From: Chris Lawrence
Sent: 18 November 2013 09:29
To: Simon Davis
Subject: Re: Planning Consultation on: FP/159/13/

**WEST SUSSEX COUNTY COUNCIL
STRATEGIC PLANNING CONSULTATION**

SUBJECT: FP/159/13

Change of use from production of timber for bio mass use (Sui Generis) to land for private outdoor fitness training (D2 Assembly and Leisure) vehicular access from the A259 with 8 bay parking area within site (resubmission of FP/102/13/). This application is a Departure from the Development Plan.
AMENDED DESCRIPTION & SUBSTITUTE BLOCK PLAN.

Site Plan

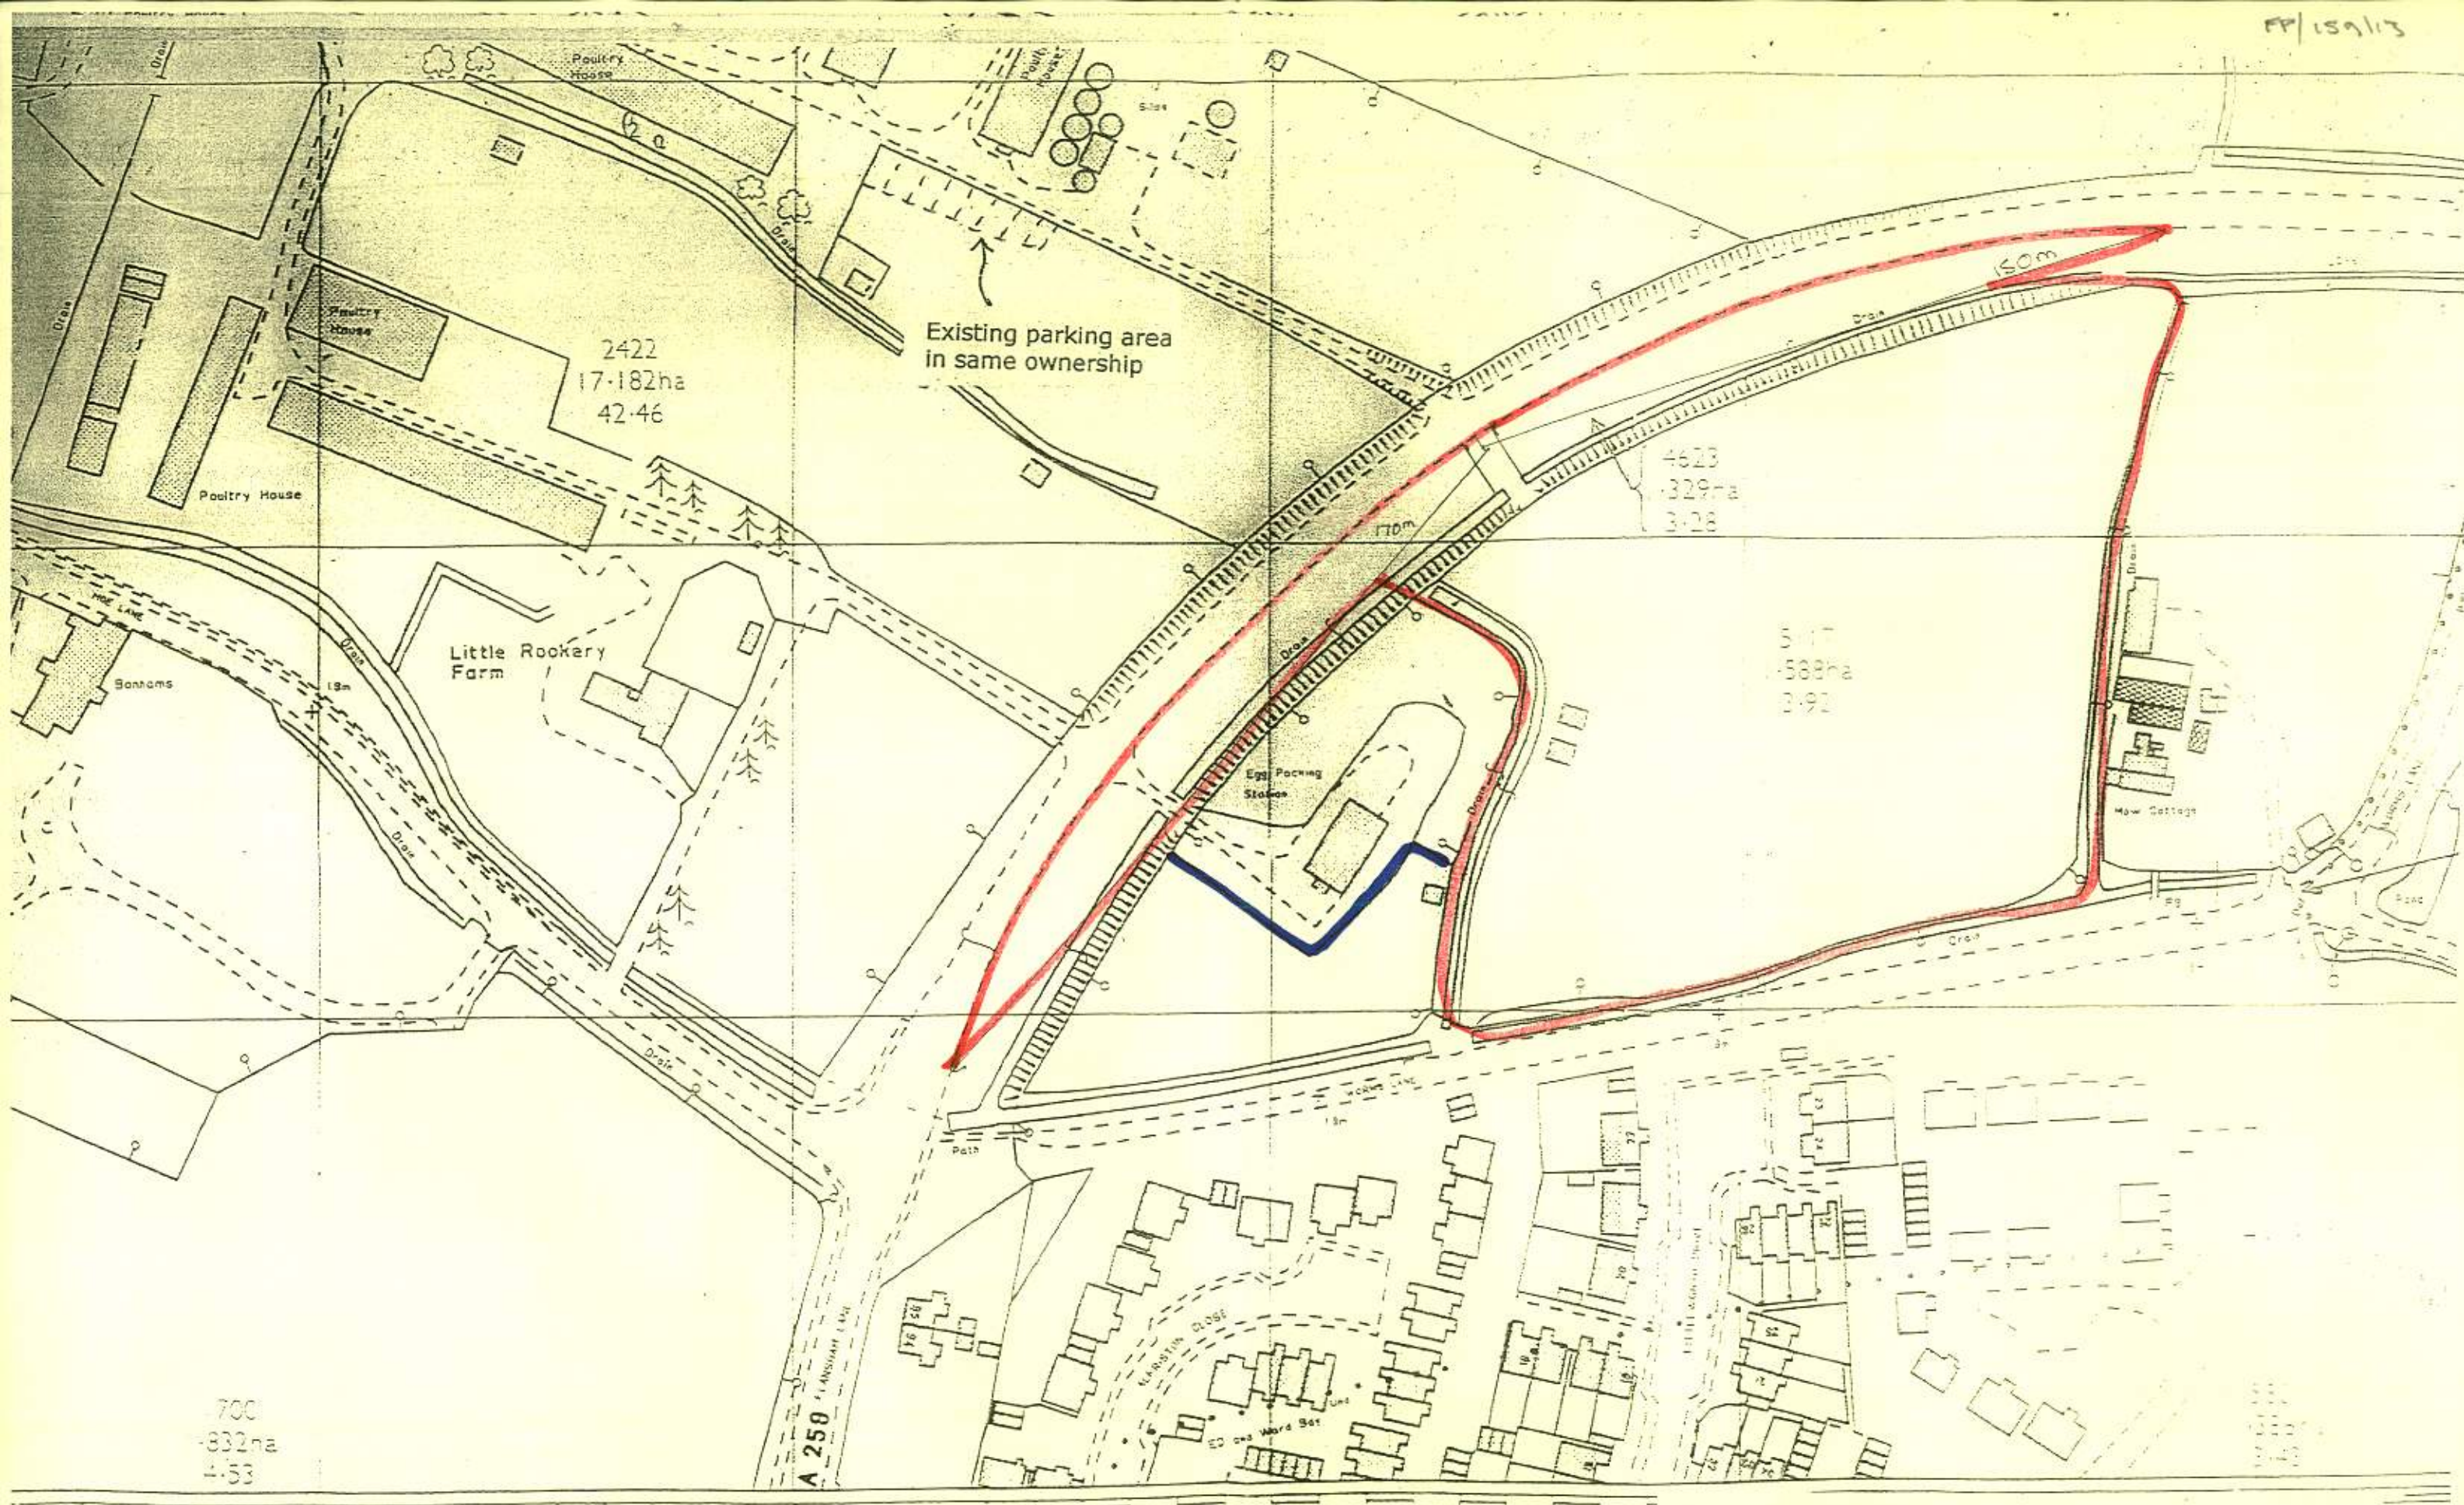
West Sussex County Council (WSCC), in its capacity as the Local Highway Authority (LHA), has previously been consulted on the proposed development. An objection was raised on highway safety grounds. A revised plan has been submitted which incorporates parking on site, thus removing the need for pedestrians to cross the A259. Direct access from the A259 proposed.

The plan indicates that an existing crossover will be used to provide access. However, from observation of the site it does not appear that the current arrangement is a formal vehicular crossover, but that access to the land has been gained by overrunning the verge and eroding vehicular tracks. Vehicles gaining access in this manner are likely to be originating from the Rookery Farm access directly opposite as opposed to approaching from either east or west along Worms Lane.

The access is located in a derestricted section of road for which the Design Manual for Roads and Bridges would be the appropriate design guidance. For a 60mph design speed visibility splays of 2.4m x 215m would be required; the applicant has provided 2.4 x 125/150m. These are considered to be substandard and no evidence has been submitted to demonstrate that sufficient visibility for the recorded road speed.

Little information is provided on the geometry of the access and whether two-way working would be possible; vehicles stopping or standing on the A259 carriageway waiting to gain access would pose a hazard to through traffic and could result in shunt type collisions. The kerb radii shown on the plan requires a very sharp turning manoeuvre which could only be undertaken at very low speeds. The sudden slowing on a derestricted 'A' road could again lead to shunt type collisions. No vehicle tracking has been provided to demonstrate that vehicles with larger turning circles, such as a mini-bus, would be able to access the site without impacting the opposing lane of traffic.

Given the classification of the road a 'Road Safety Audit: Stage 1' would be required.

It has not been demonstrated that safe and suitable access can be achieved as required by paragraph 32 of the National Planning Policy Framework, that the proposed access arrangements will not present a risk of death or injury in accordance with Strategy 4 of the WSCC Local Transport Plan, and that the development allows for the safe movement of vehicles as required by Arun Policy GEN7.
